Planning Officer: Ms M Tomalova

Planning Application Ref: BN/66/19/PL

Location: Land off Canal Mews Barnham PO22 0DP

Description of works: Erection of 3 No dwellings

Drawing No. 02 - Tree Retention and Protection Plan
Land to the East of Barn Rise, Barnham

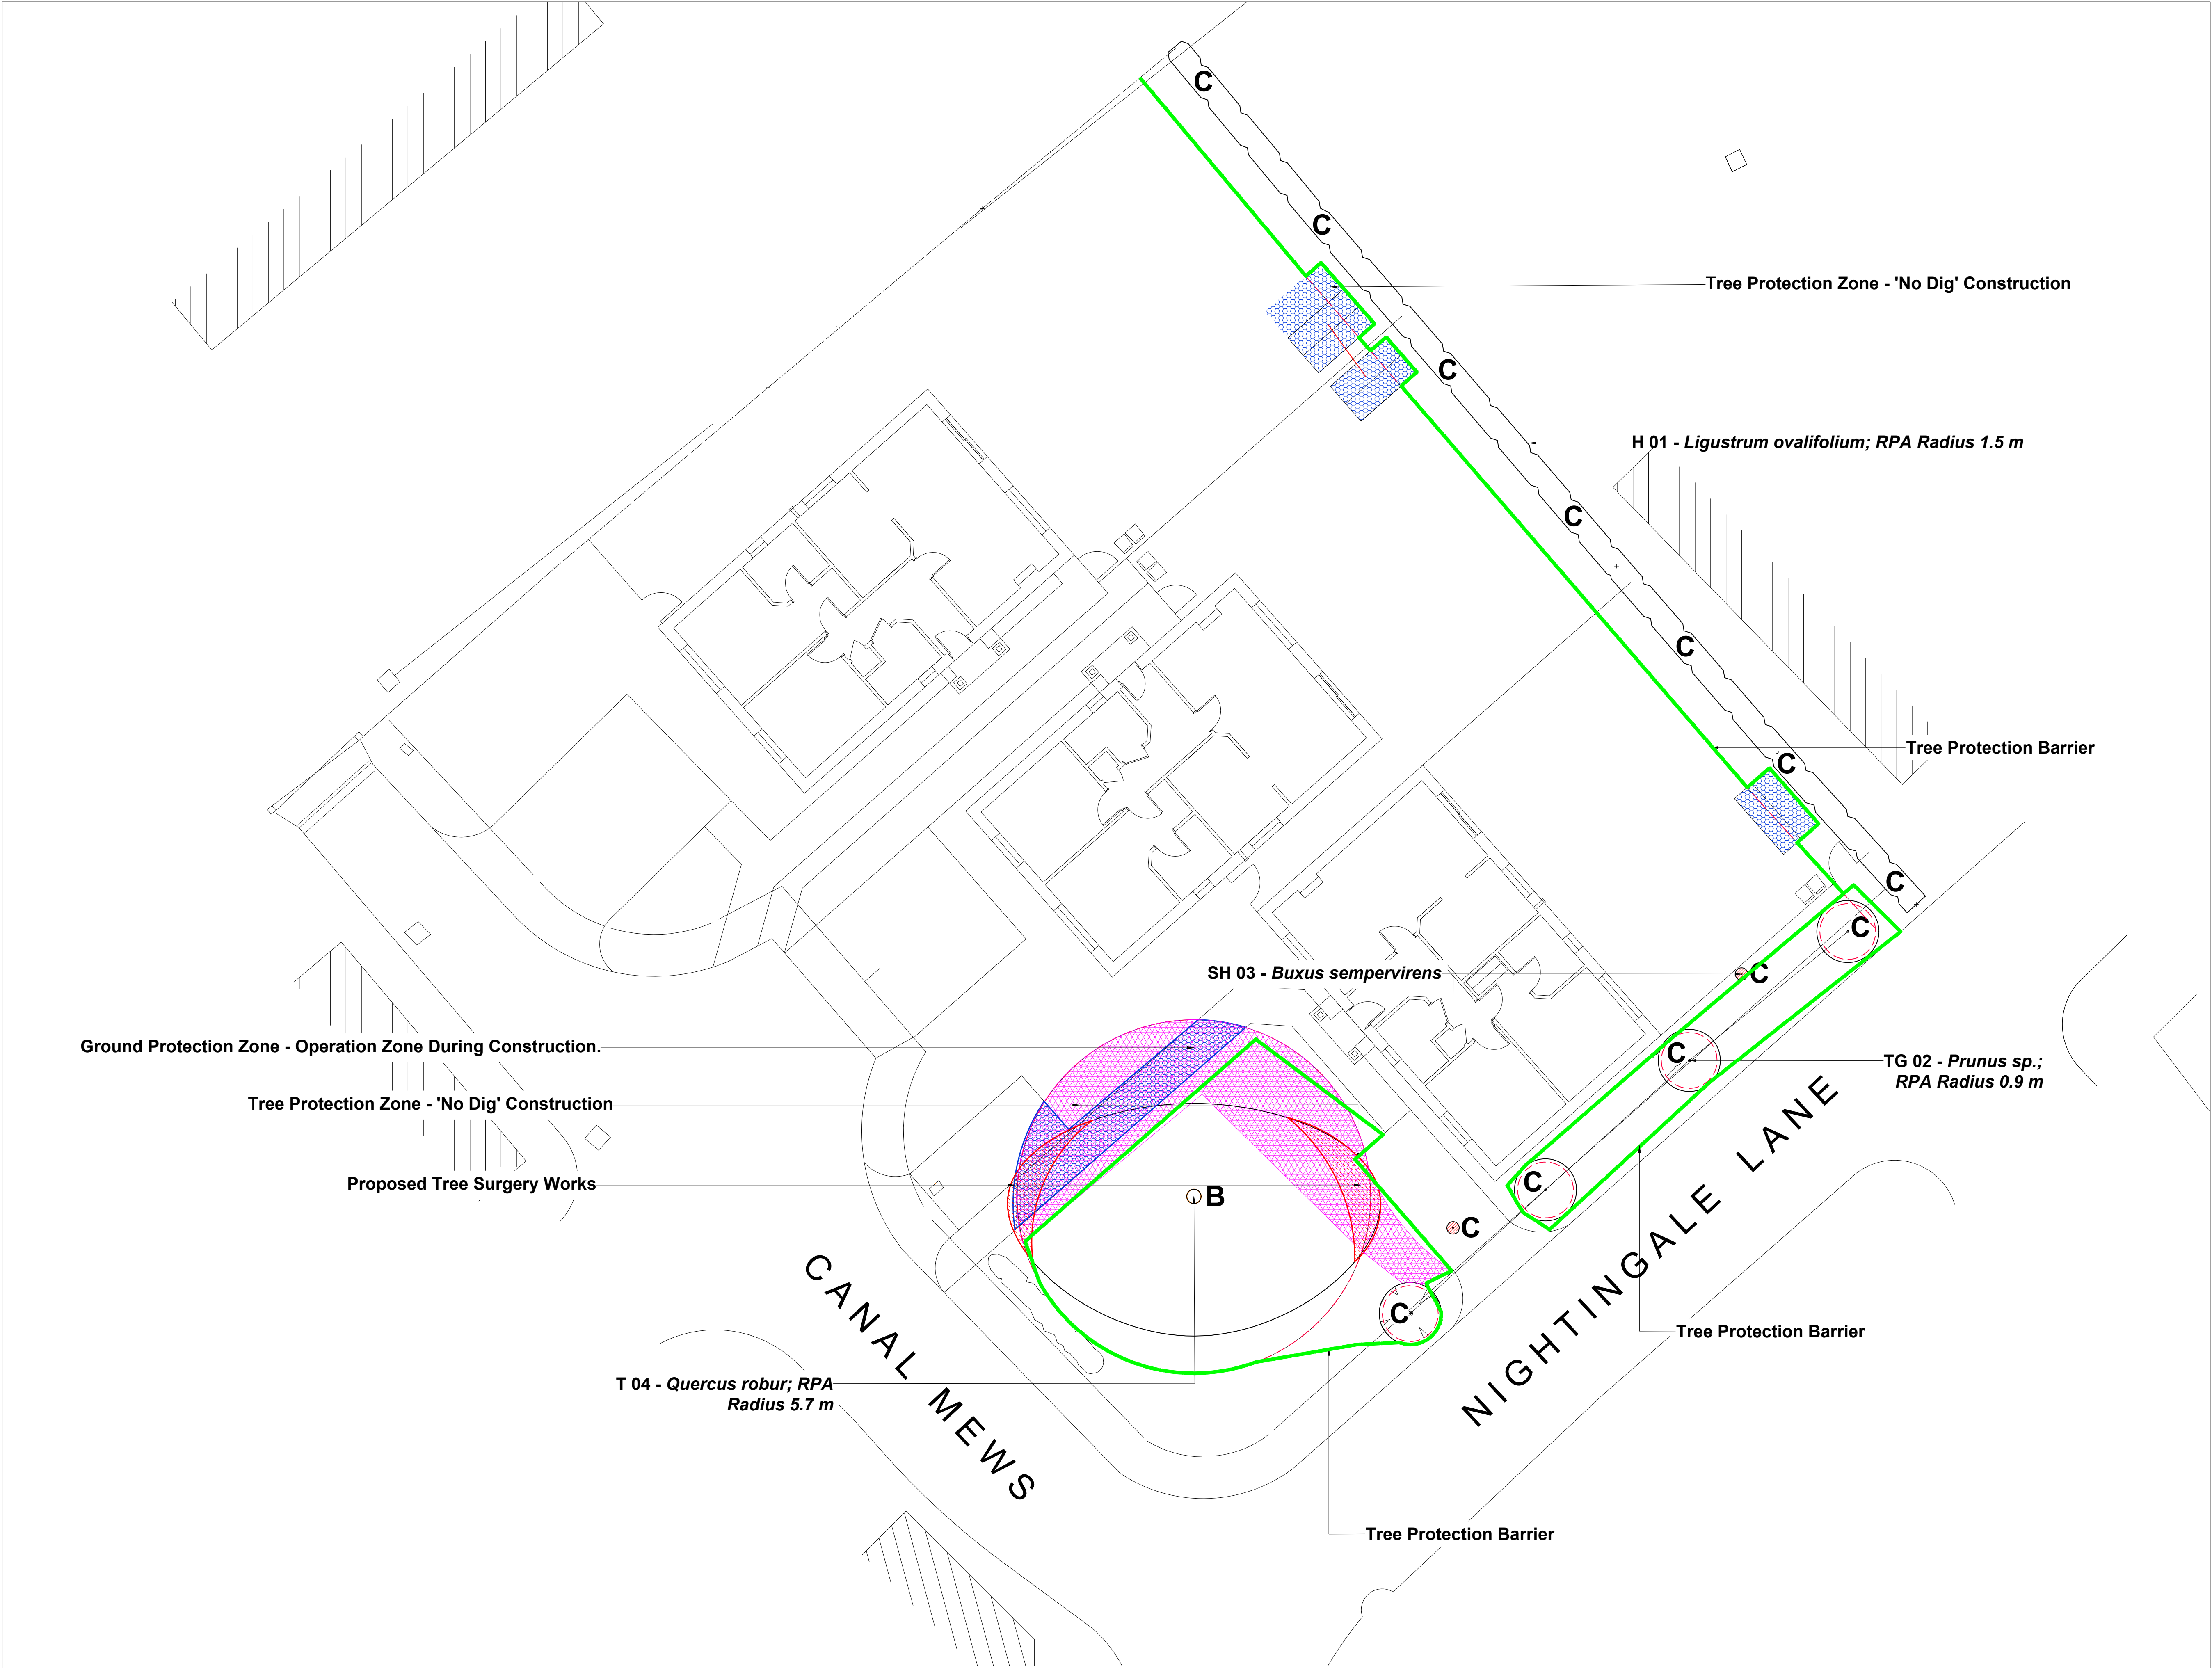
- The current proposed layout is going to impact heavily on the only significant tree (T04 – oak), both above and below ground. Although achievable in principle by adopting the tree protection measures proposed; there is nonetheless a risk that attaches during such incursion of root protection areas (RPAs). This is especially significant where the tree in question is so prominent, of current high public amenity value, long-term potential and has endured recent ground disturbance/amelioration on remaining aspects.

- The applicant has submitted a revised site layout plan, dwg. no. 1705-12. This illustrates avoidance of RPA incursion which is a welcome advance on the previous layout. That said, construction in the form of vehicle parking bays is proposed on two aspects and tight against the RPA perimeter. The practicality of working so close means that were we to approve that layout, some RPA incursion would have to occur. Of greater significance, is the effective containment of the tree by inhibiting future root growth.

- Plot 1 is going to experience a high level of seasonal nuisance from the presence of (T04 – oak), which will increase if the tree remains healthy and achieves its current potential. Branches will overhang those parking bays and represent a significant nuisance to vehicles (faecal deposits from roosting birds, falling leaves/acorns, dead twigs and small branches) which it can be anticipated will give rise to tree work applications that would be difficult to refuse.

- It seems to me that a determination to provide 3 units will put this tree under excessive pressure and compromise its long-term health and vitality. If the plot layout can be reconfigured or unit quantity reduced so as to leave the nominal root protection area of T04 inviolate – only then would I be able to lend the scheme my support. I am pleased to see that the RPA has been better respected within the revised layout. That said, 'future residential pressure to prune' remains a likely outcome if we approve this layout.
